TSC STEVENSON LIBRARY MAJOR REFURBISHMENT SSD 8922

We write in response to the submission prepared by the Heritage Council, correspondence dated 3 October 2018 in respect to the project above.

SSD1.02/17-413

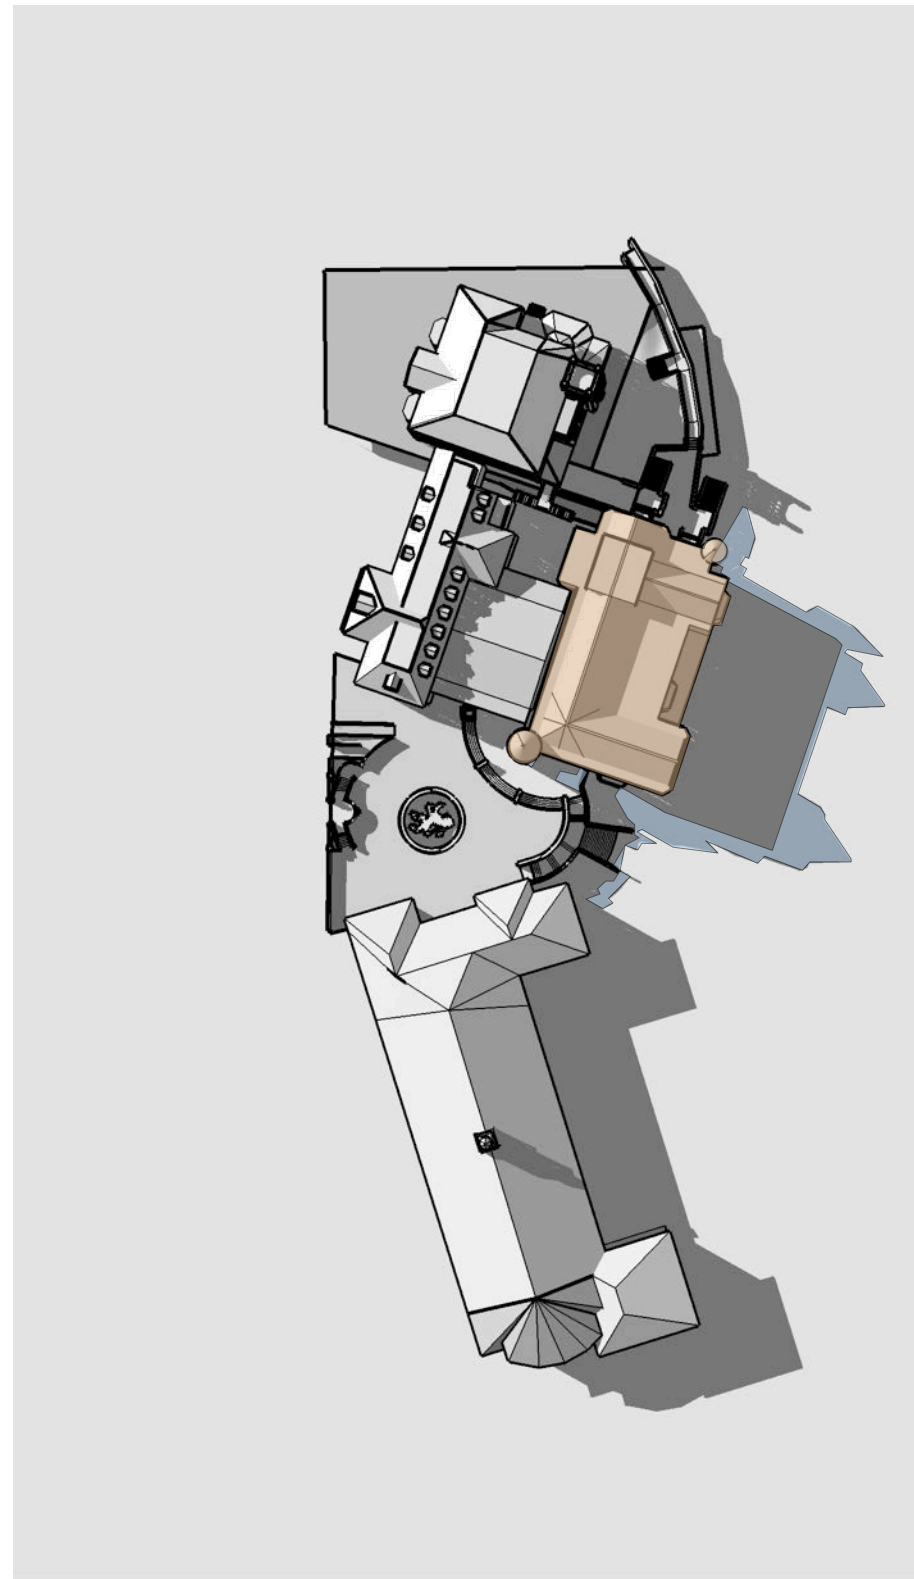
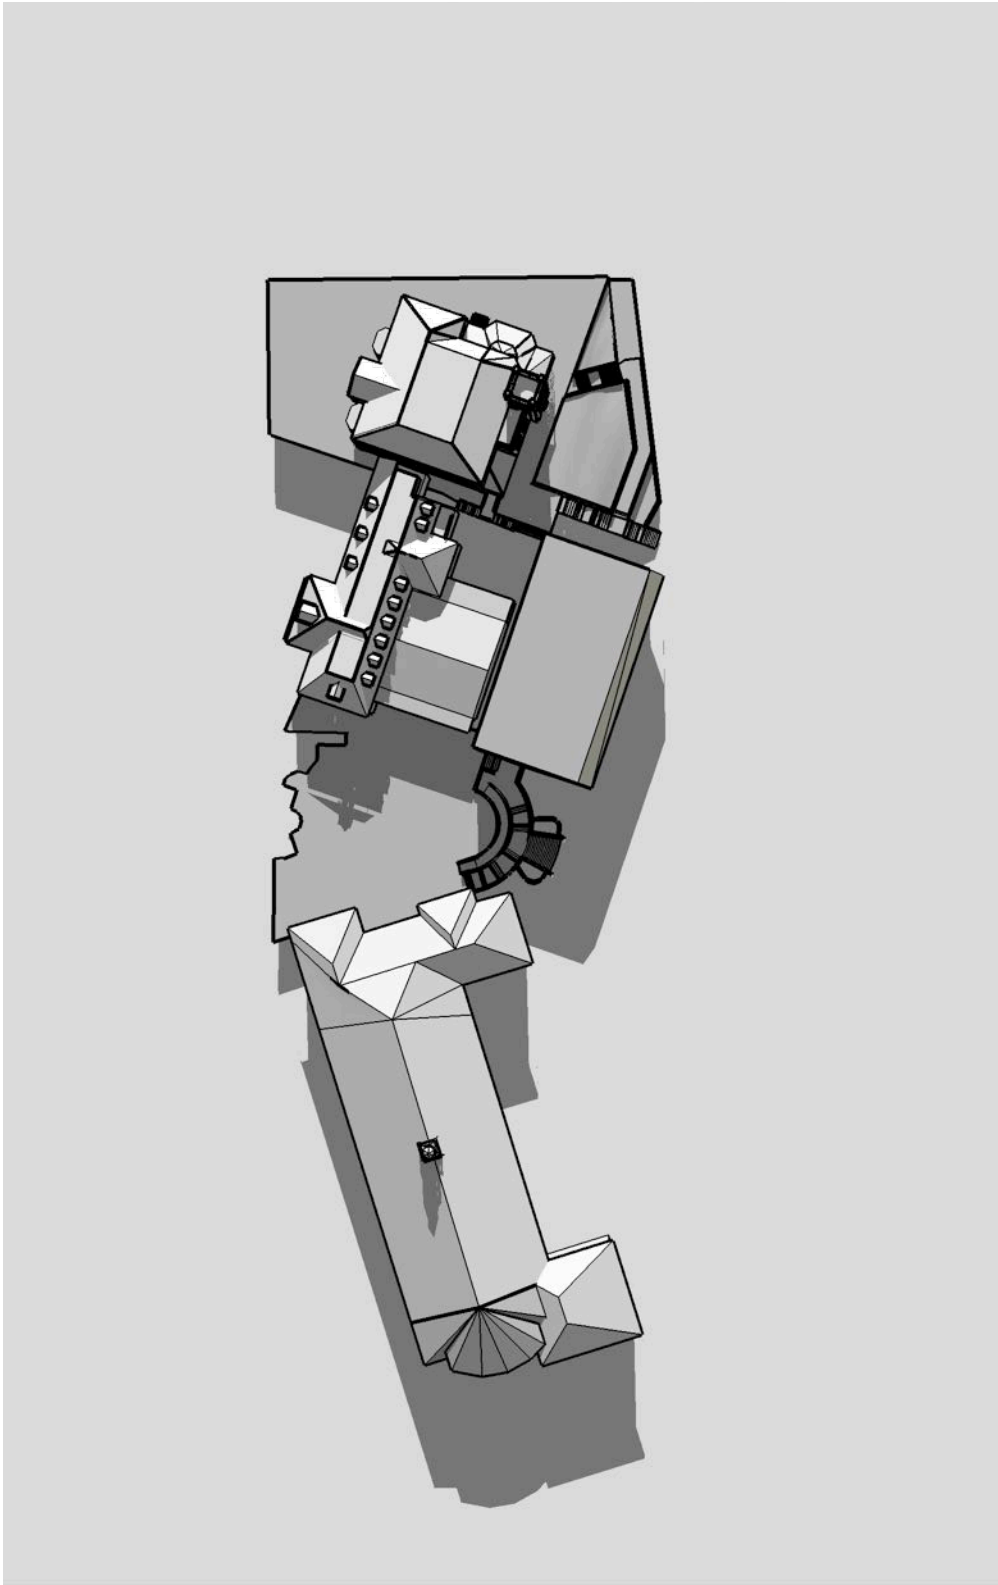
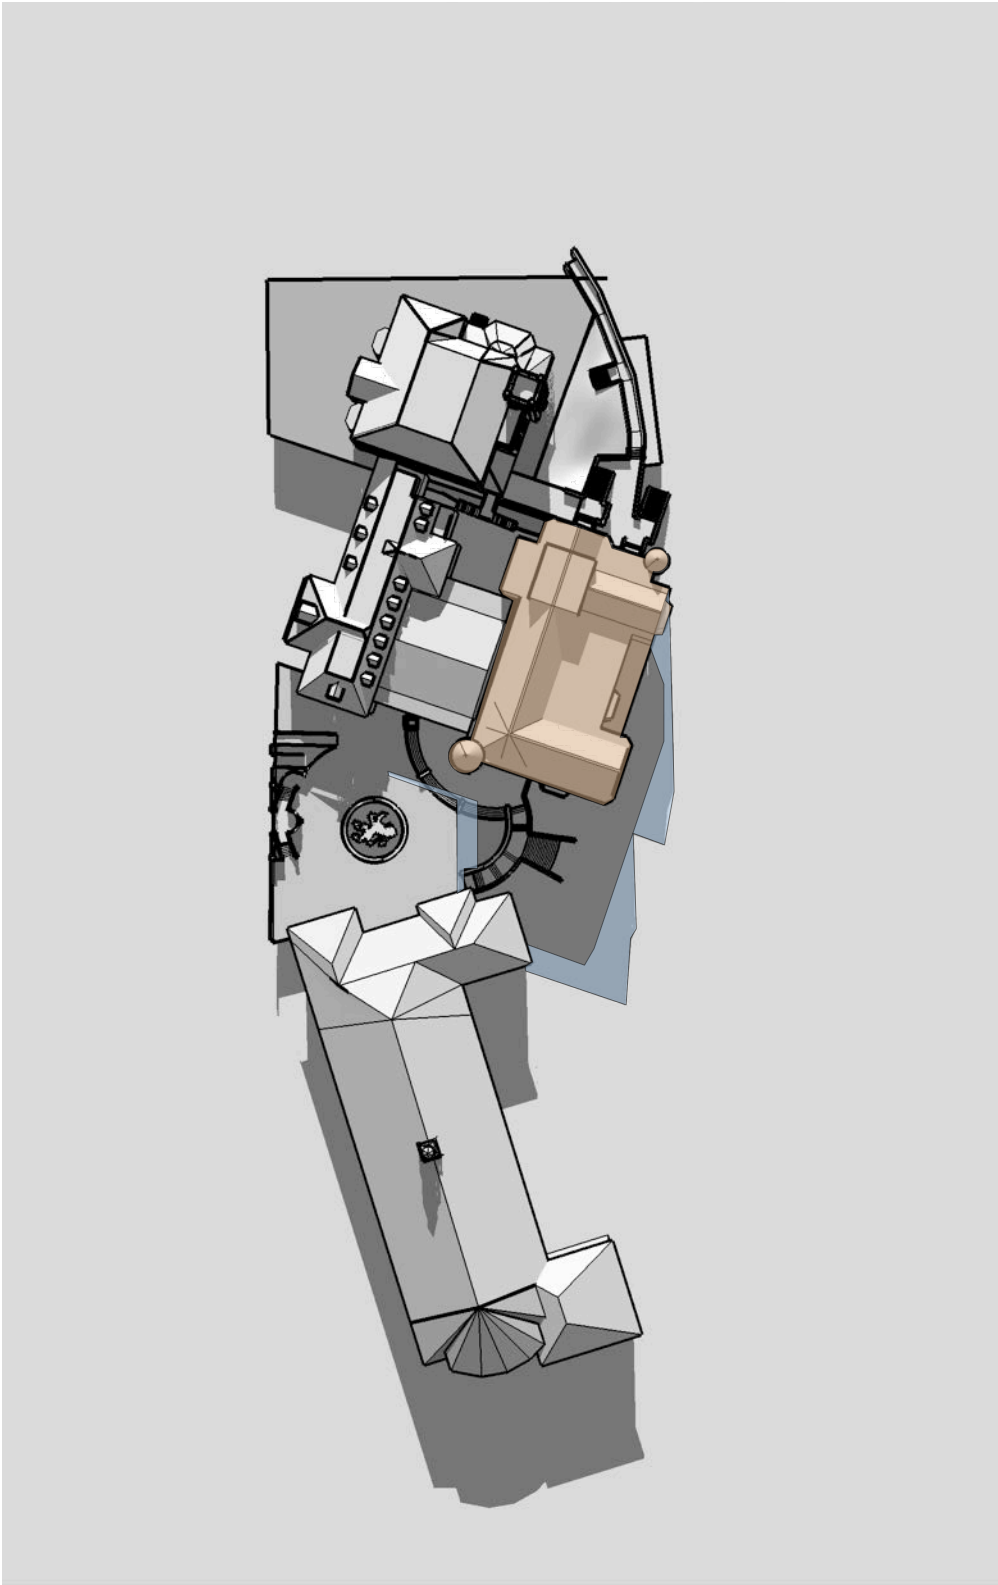
- Secondly that the proposal will overshadow Aspinall House. Given the location of the Library to the south east of Aspinall & its siting on the Oval at lower level this is not possible, we refer to the shadow diagram study drawings SSD1.02/17-412 S1 to SSD1.02/17-423 S1 which demonstrate both the existing shadow arrangements and the proposed shadow impacts. No new shadows are cast across Aspinall House as a result of the proposal.

SSD1.02/17-405

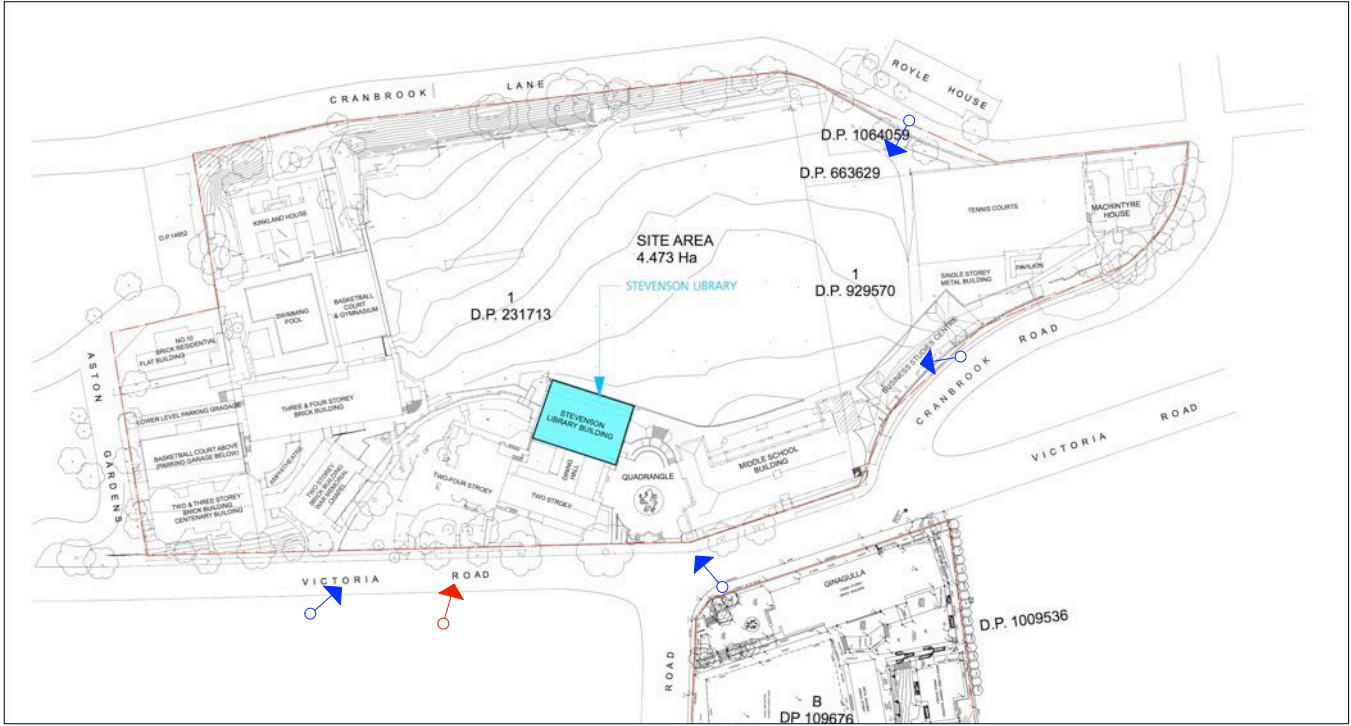
The *before* and *after* impacts are described in the following drawings:

The view analysis demonstrates that the Library is not and will not be visible beyond Aspinall House from Victoria Rd.

Aspinall House is largely obscured by the current library structure when viewed at the public vantage point off Cranbrook Lane, with only part of the tower and a portion of ridge line visible beyond it.

While the partial view of the ridge line is lost in the proposal it is largely immaterial given that Aspinall is not visible beyond the Library in any case.
